Saggart Village Residents' Association
Saggart Village Heritage & Arts Centre,
Garter Lane,
Saggart,
Co. Dublin
D24 DX43

Strategic Housing Unit
An Bord Pleanála
64 Marlborough Street
Dublin 1
D01 V902

RE: Observations to the proposed development by Kelland Homes Limited and Durkan Estates Ireland Limited "Boherboy" (ABP-313145-22)

DRAWING TITLE:
Site Layout Plan Public Open Space

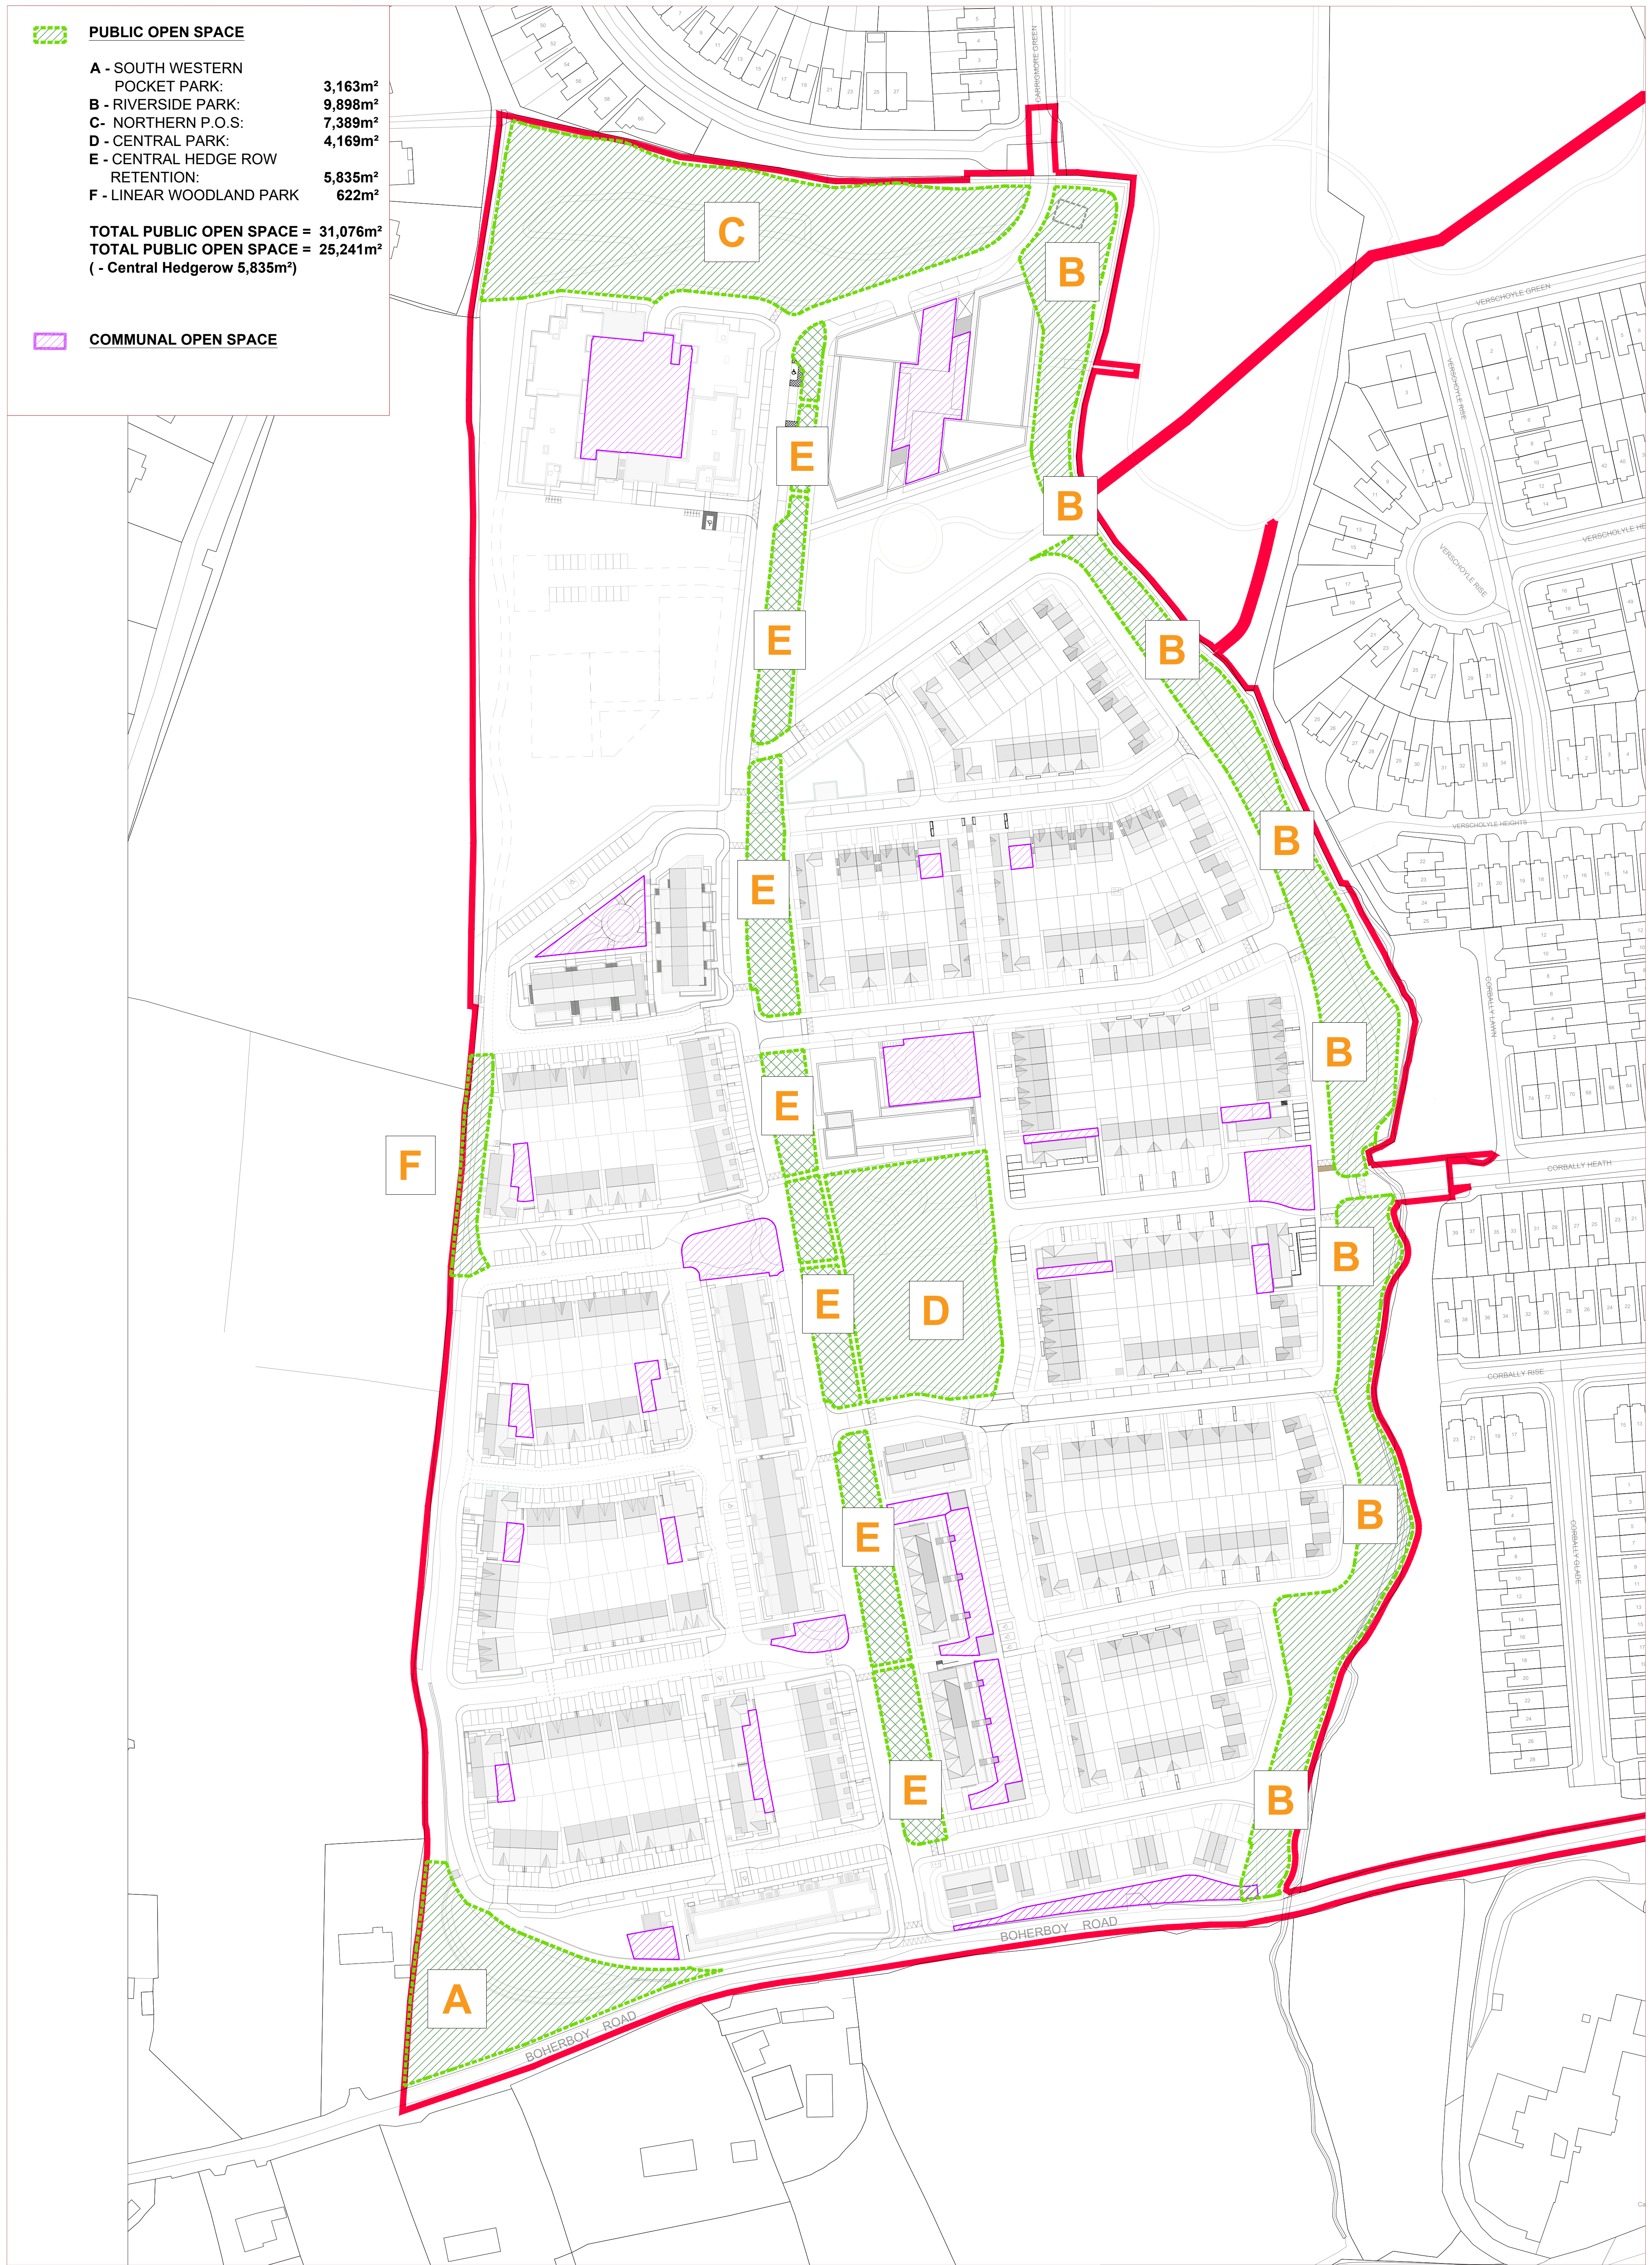
2. The site notice indicates buildings of 4 and 5 storeys, however the site layout map indicates building of 2 and 3 storeys. It is impossible to tell from the documentation submitted where the proposed 4 and 5 storey buildings will be situated. We proposit that the documentation submitted is deliberately misleading. As such it is our belief that the application is invalid as a result of inadequate and accurate detail in the site layout map.
